## **Exhibition of Environmental Impact Statement (EIS) for the Honeman Close Data Centre (SSD-58601963) (Blacktown City)**

Thank you for your referral inviting advice from the Heritage Council of NSW on the State Significant Development (SSD) proposal for the construction and operation of a 5 storey data centre with supporting infrastructure, vehicular access, car parking, and landscaping.

Figure 2: Location of the Conservation Area and the Landscape Buffer Zone

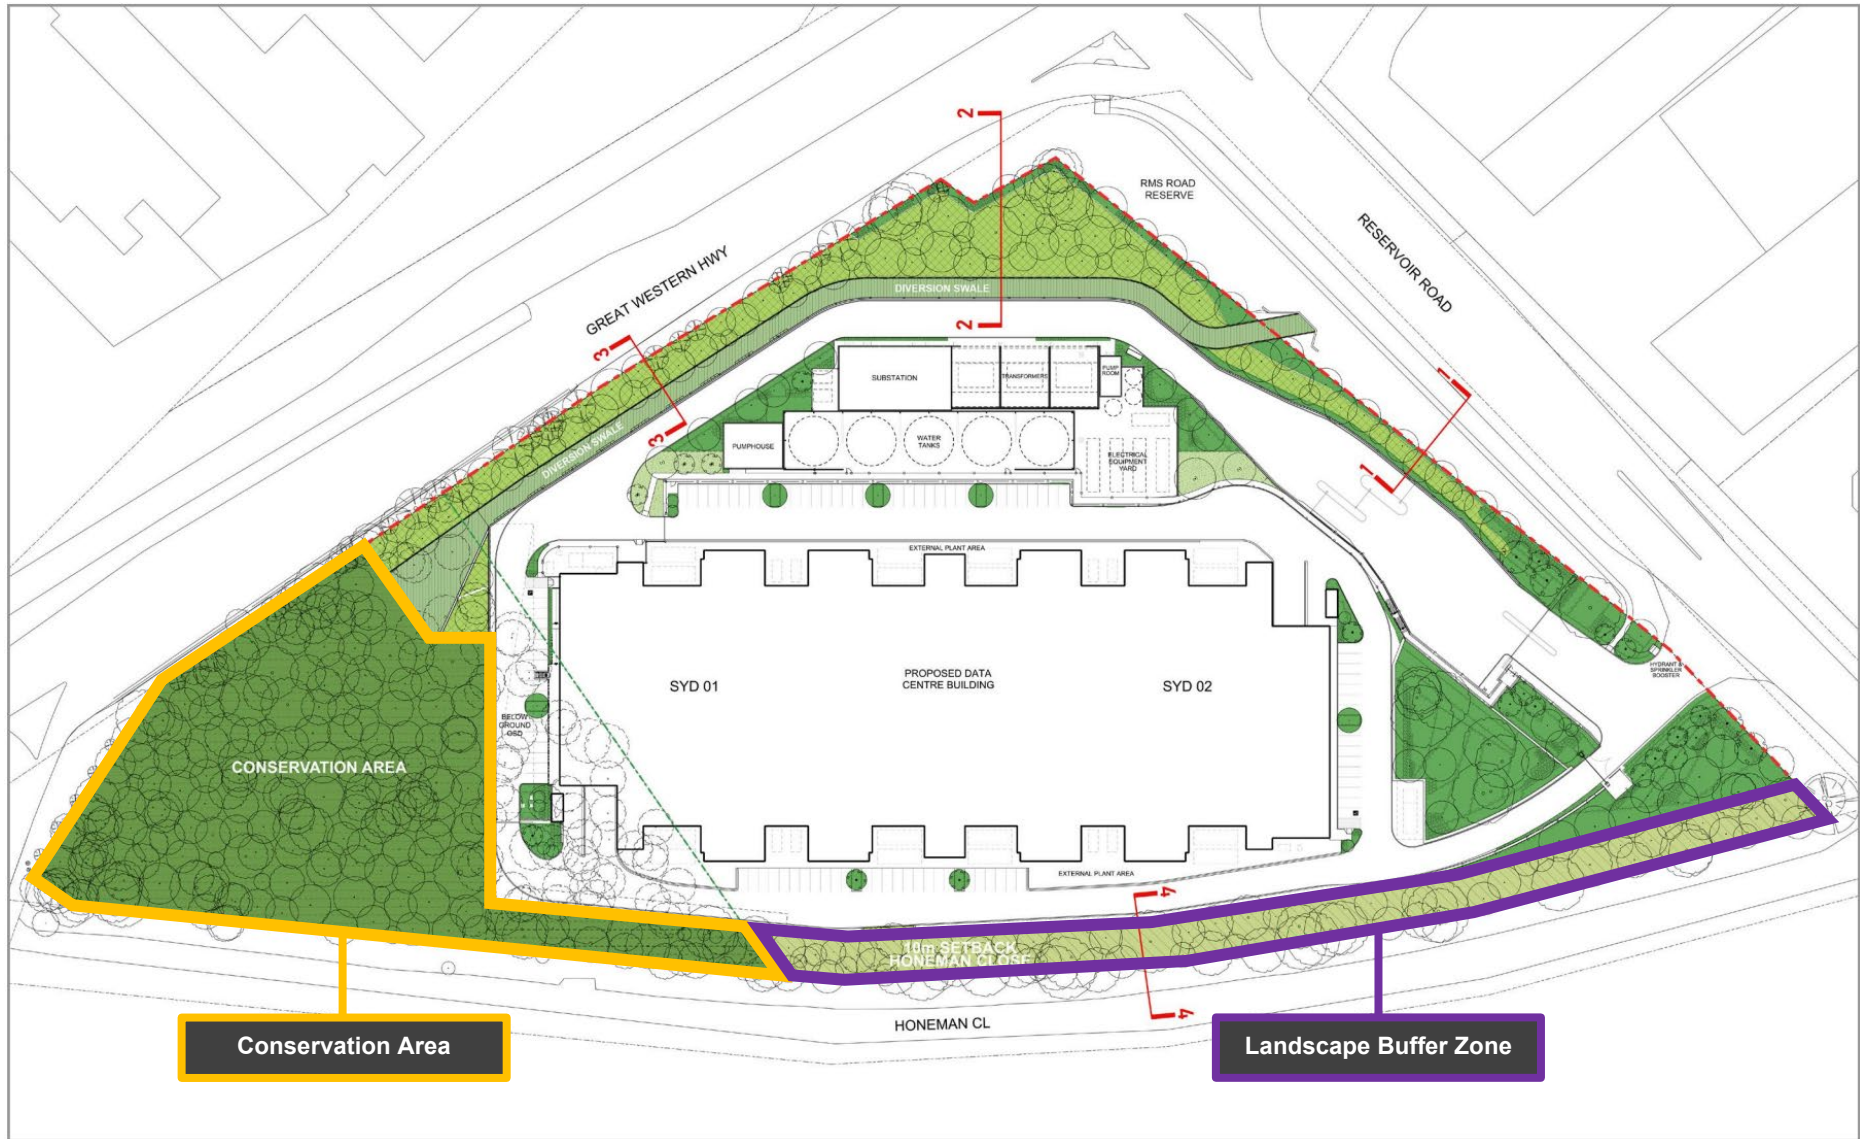
- HNSW supports the design decisions to minimise the visual impact to the historic road alignment by providing a 10m landscape buffer in conjunction with a further 13-16m building setback.

- HNSW supports the mitigation measures recommended in section 8.1 of the Statement of Heritage Impact relating to:
  - Retention of existing mature native trees and other Cumberland Plain vegetation within the 10m landscape buffer.

- Additional plantings within the 10m buffer to be Cumberland Plain vegetation with a mix of planting heights.
  - Not using Honeman Close for any construction or landscaping activities.
